Hornsea Project 4 DCO Examination

Post-Deadline 8 Additional Information

Johnston Protective Provisions Plan

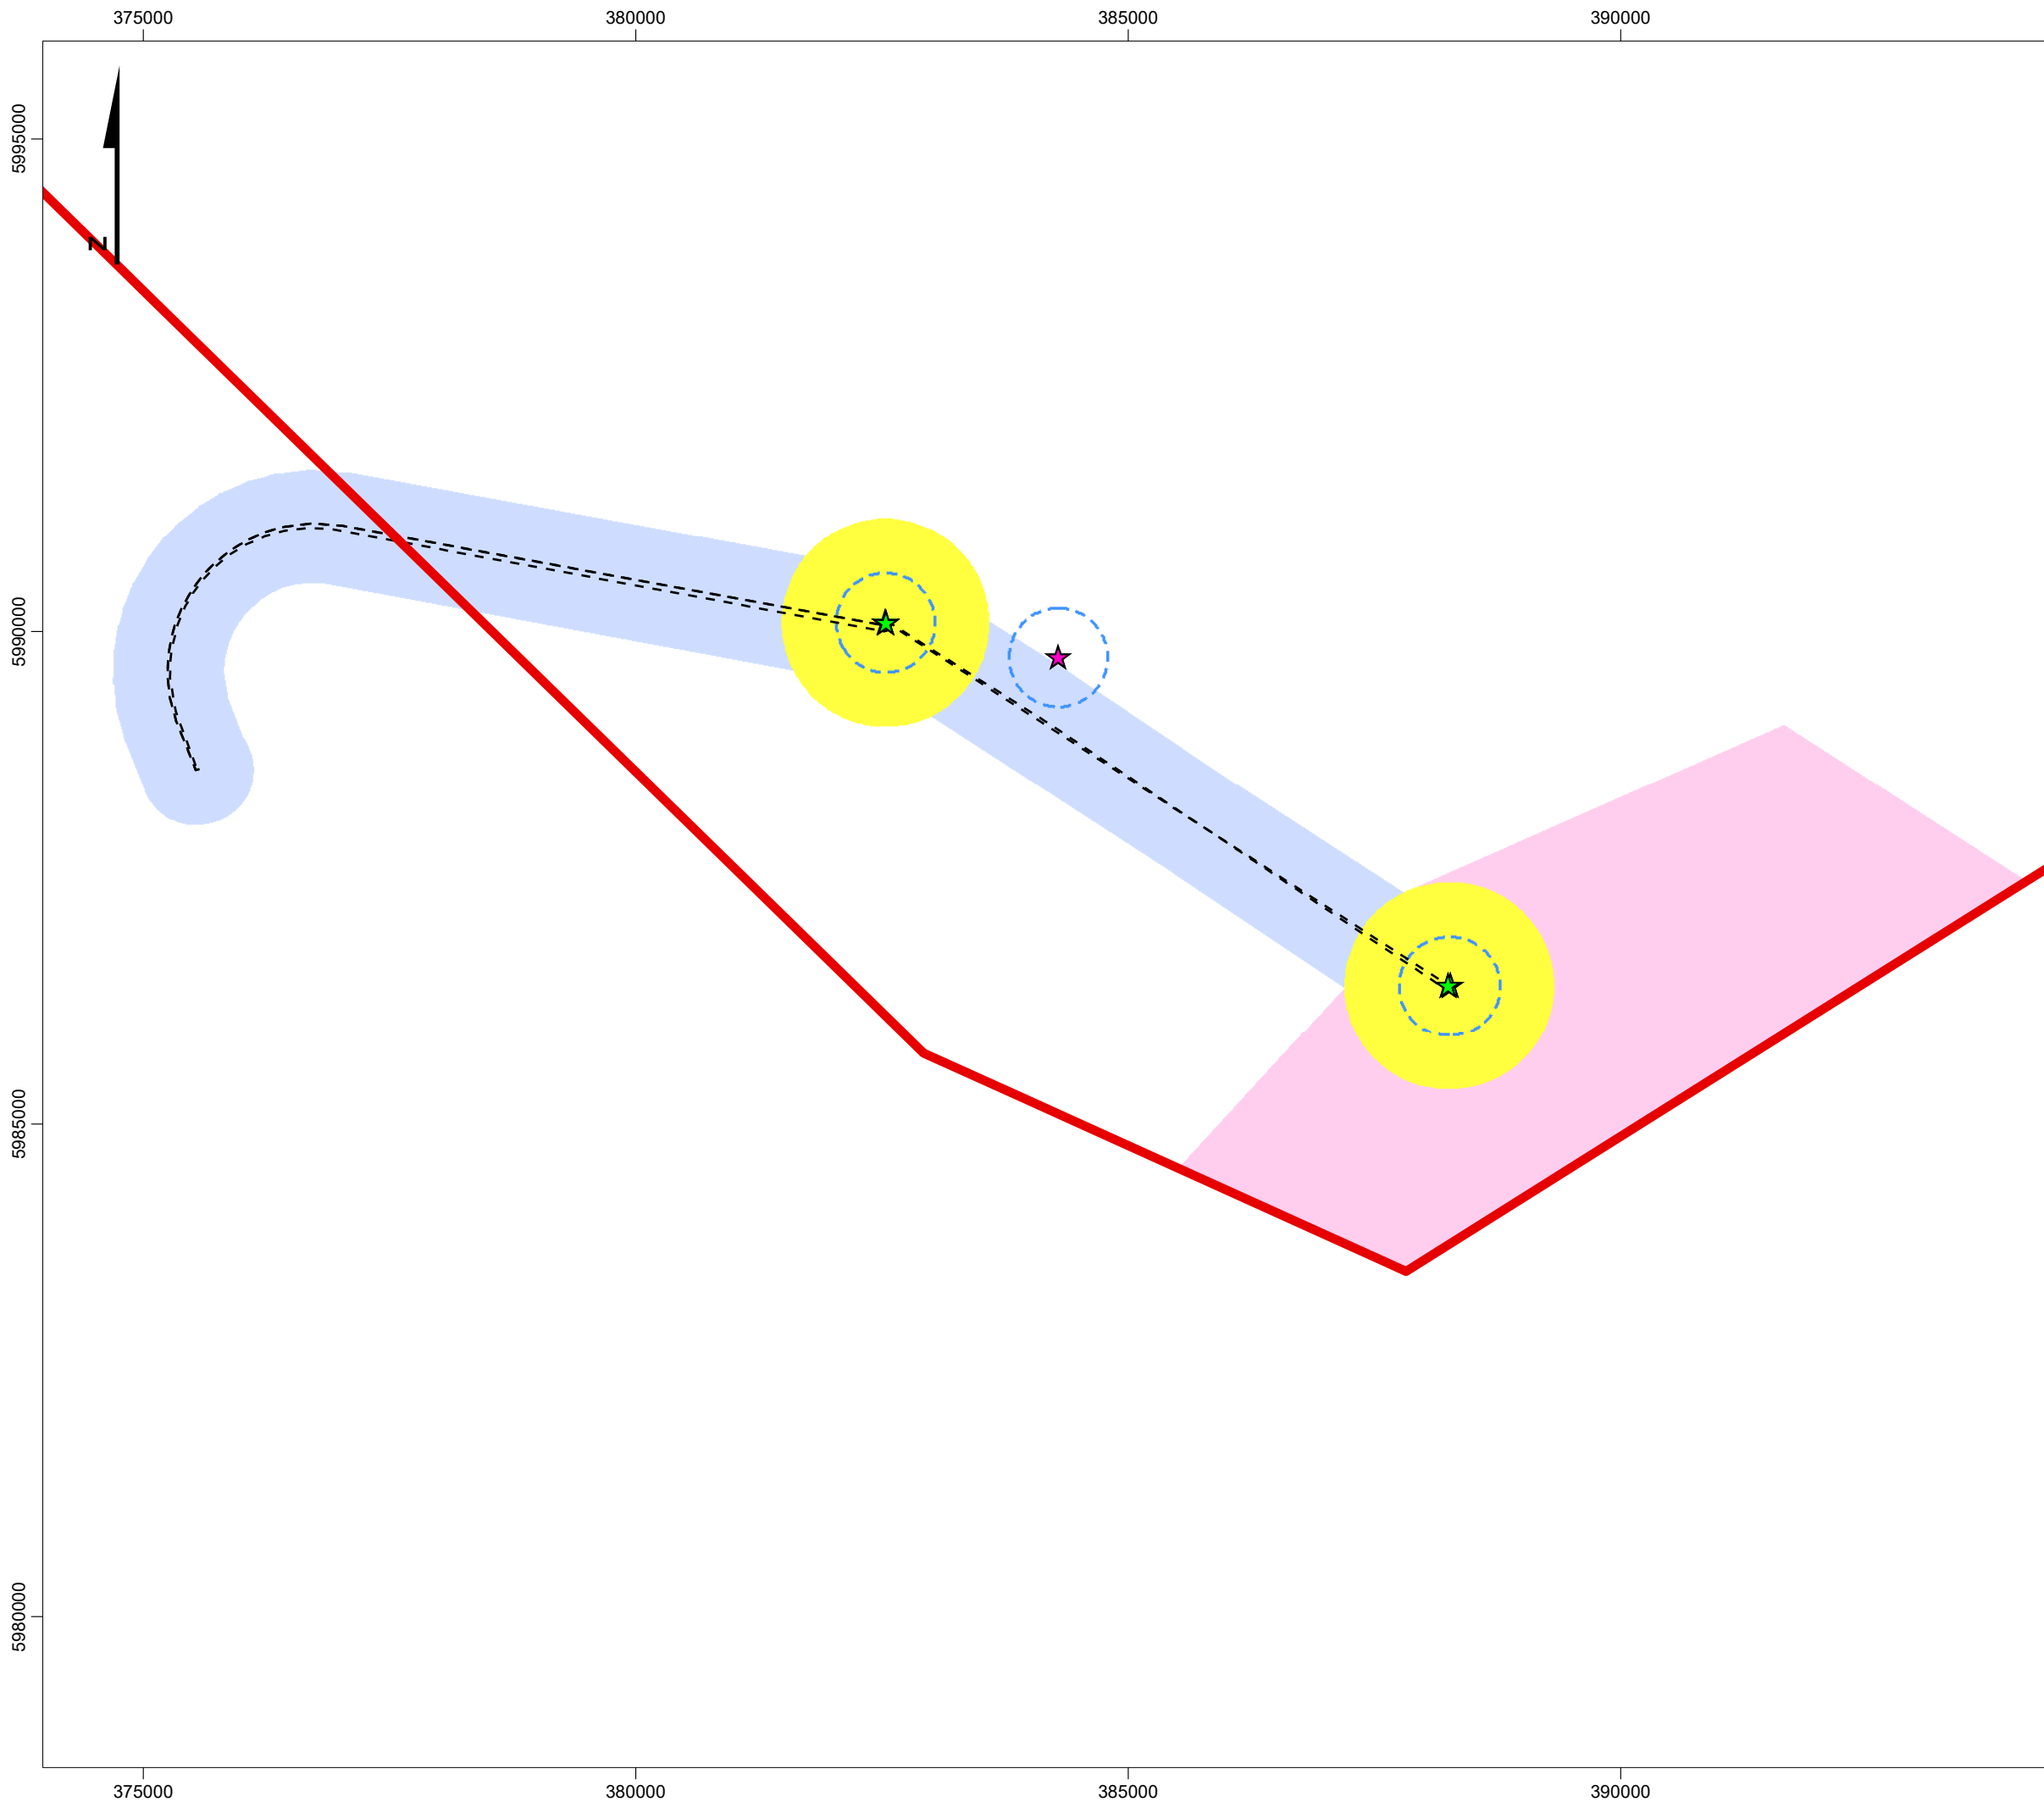
Harbour Energy re-iterates that its existing proposed Protective Provisions (a 3nm radius around each wellhead in addition to the marine corridor) stand. These Protective Provisions would keep the Johnston Field outside of the proposed Hornsea Project 4 windfarm array and thus permit Johnston Field operations to continue with an acceptable degree of disruption.

- In order to operate flights to the Johnston Field, a minimum of a 1.6km obstacle free radius (in most directions) is required around each wellhead and aviation corridors with a minimum of 1.4km wide obstacle free airspace would be required to and from each wellhead. Such arrangements would result in significant delays to rig programmes and corresponding additional costs for which Harbour Energy would need to be compensated.
- Given the limited times during which simultaneous operations will be required, the Applicant could lock some wind turbine generators to increase the available airspace to provide the minima set out above.
